October 12, 1981

Re: OFFICE BUILDING ON MOON NEAR INDIAN SCHOOL DRAINAGE REPORT

Re: Office Building on Moon  
near Indian School  
Drainage Report  
DGA Job No. 556.12

EXHIBIT V

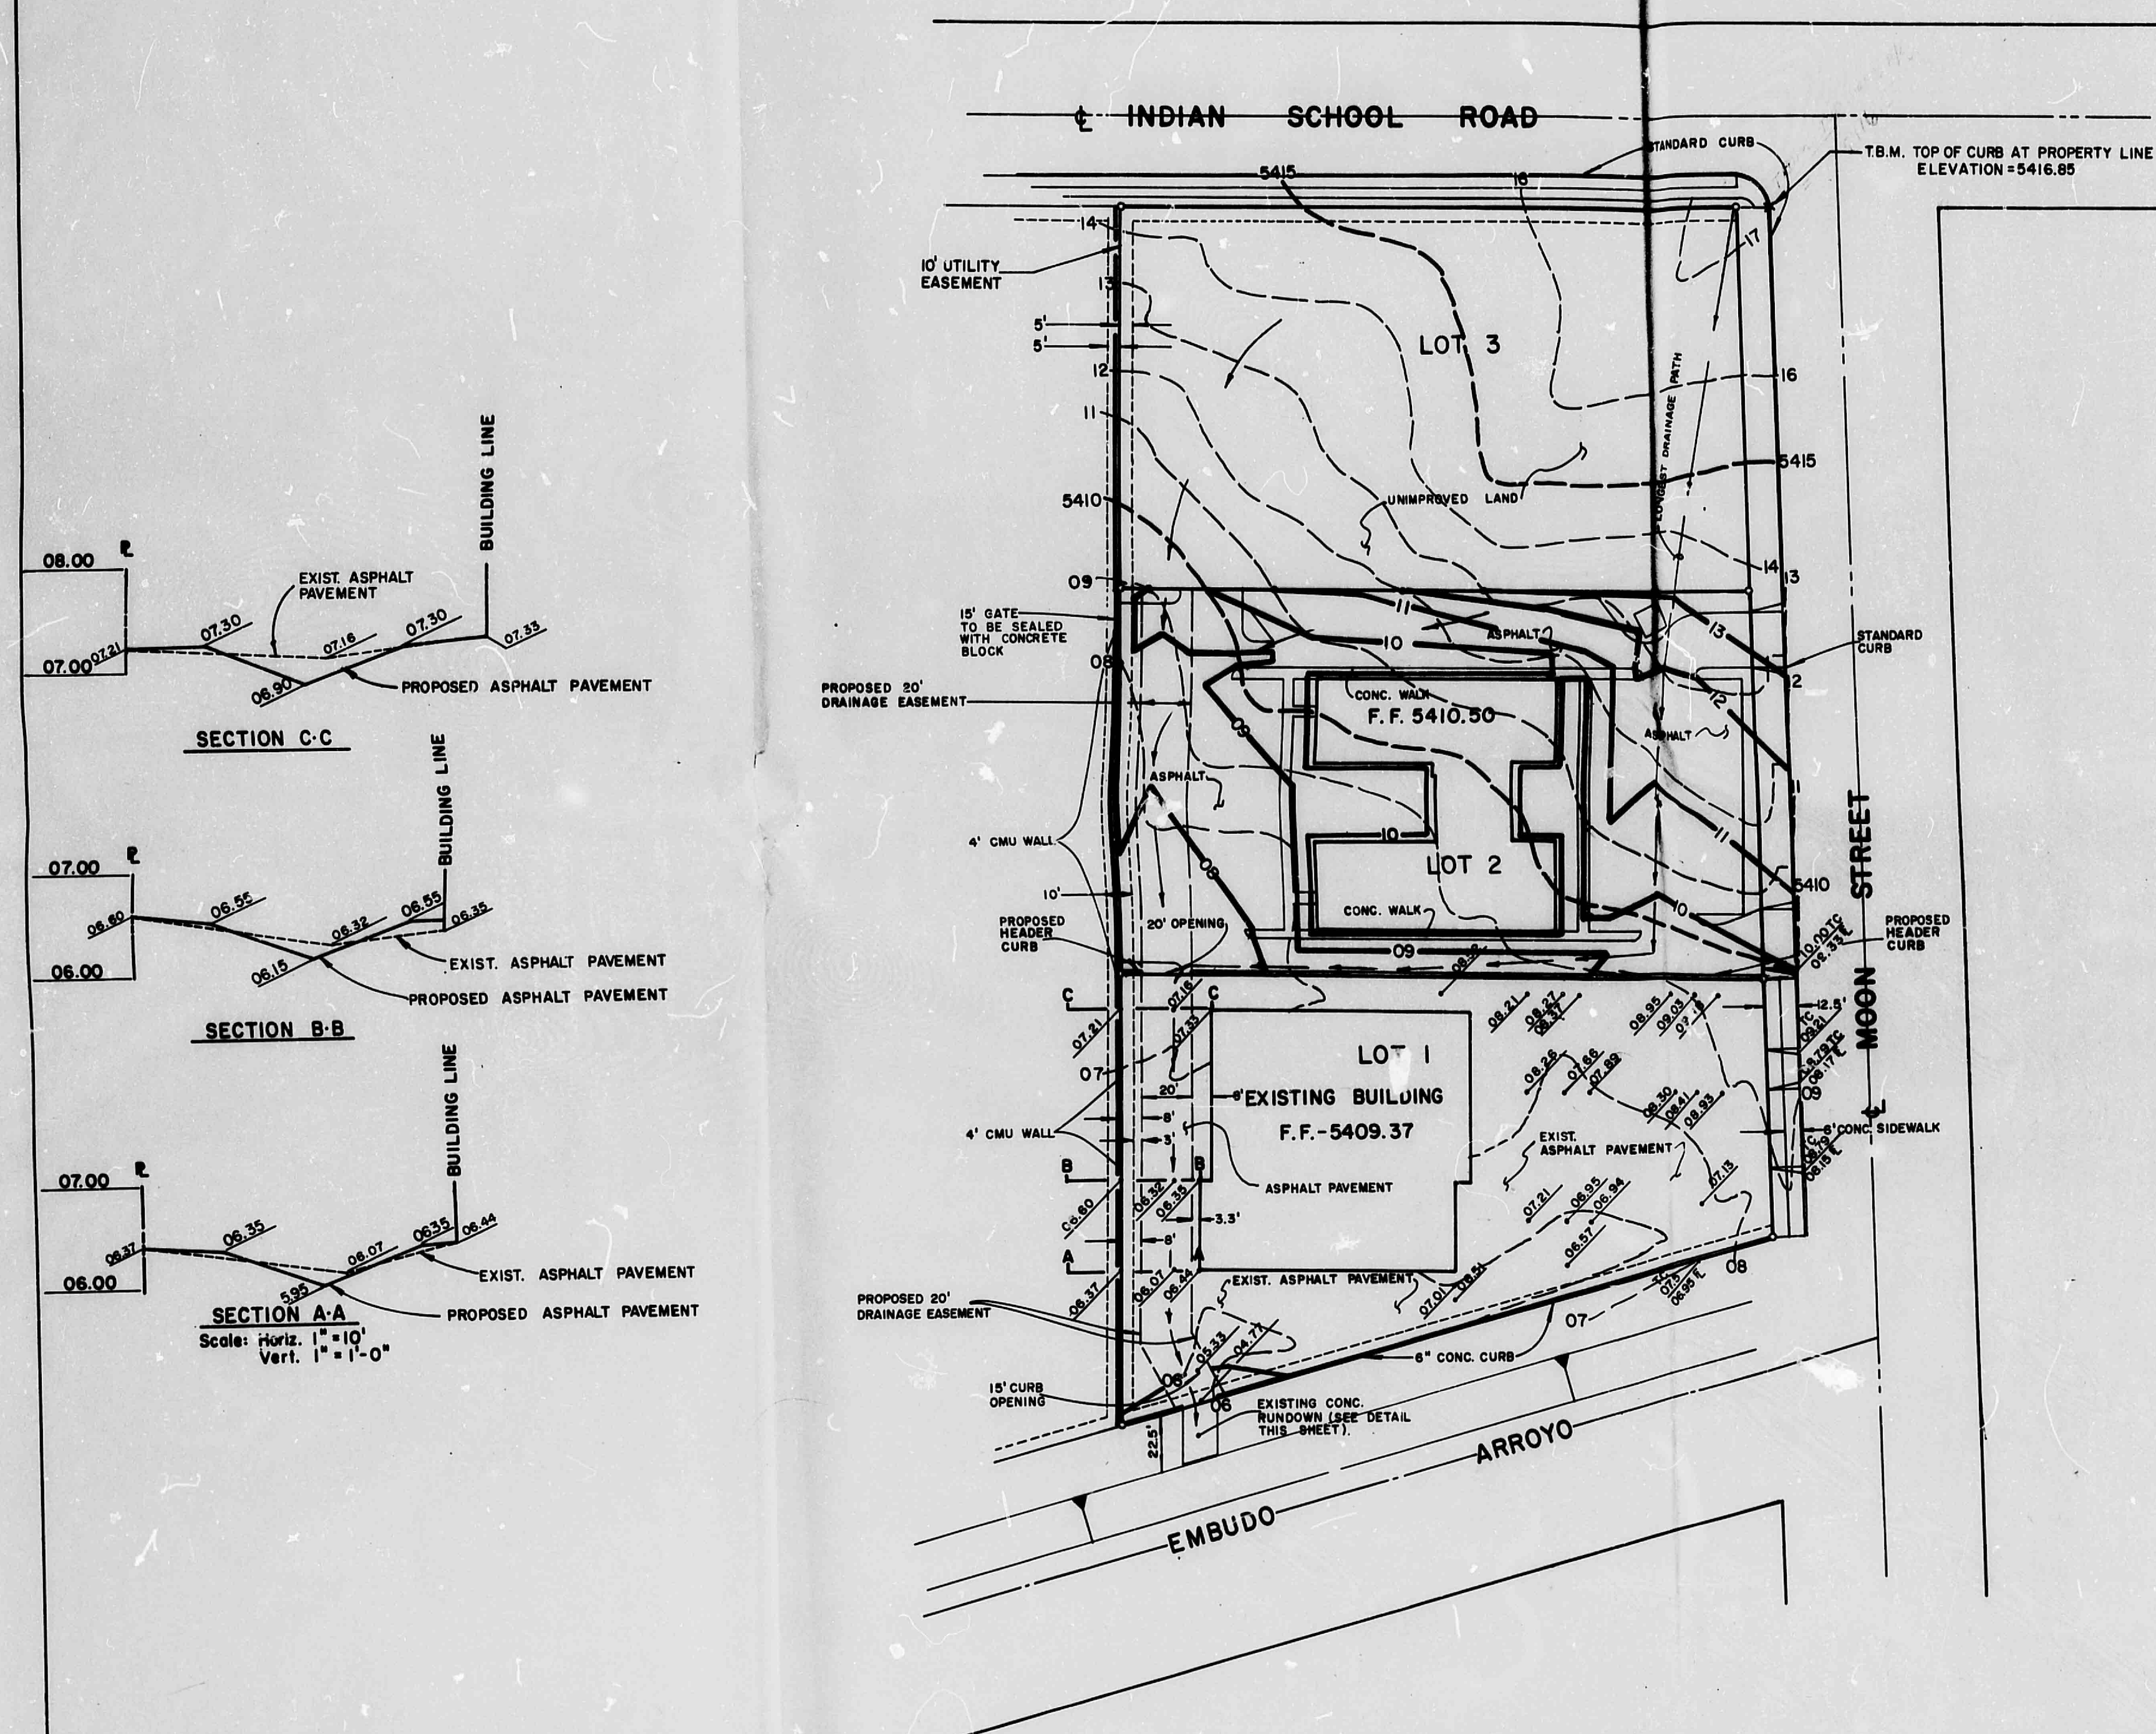
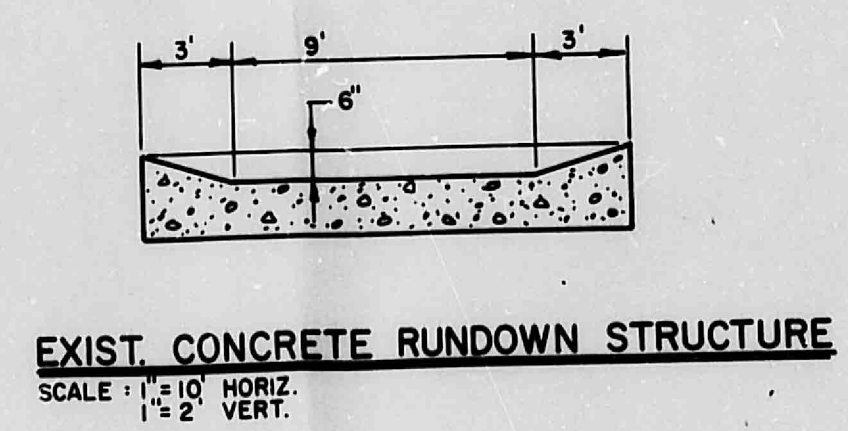
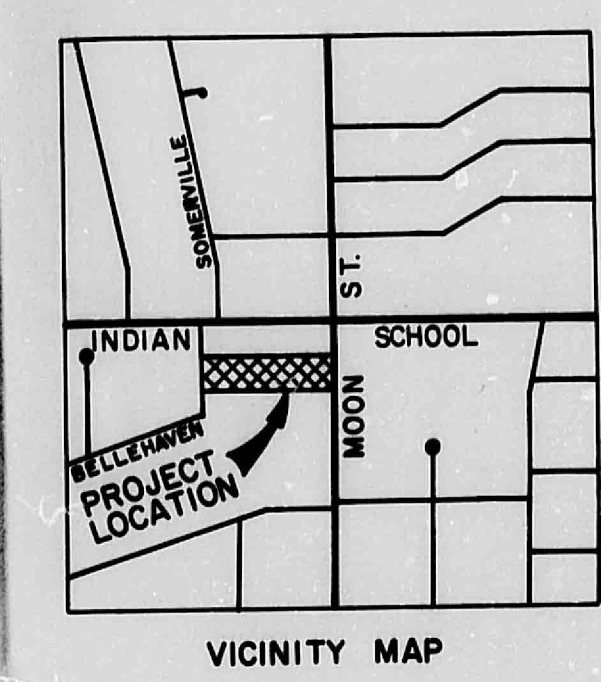
1. The proposed drainage scheme is based on the premise that the owner of Lot 1 will allow an easement through his property and the regrading of the existing parking area. This office needs to be supplied with a letter from the Lot 1 owner stating that he is in agreement with the proposed plan;
2. The following items should be placed on the drainage and grading plan:
  - a. Engineer's stamp, signature, and date
  - b. The vicinity map with Zone Atlas Page No. and legal description
  - c. The location and description of the temporary bench mark used for datum control
  - d. The existing curb and CMU wall identified as such
  - e. The elevation at the property line and driveway flowline
  - f. The direction and location of roof drainage
3. Is a sidewalk going to be constructed on the east side of the property?

1. Two copies of a reciprocal drainage easement are enclosed.
2. See revised plans.
3. See revised plans.
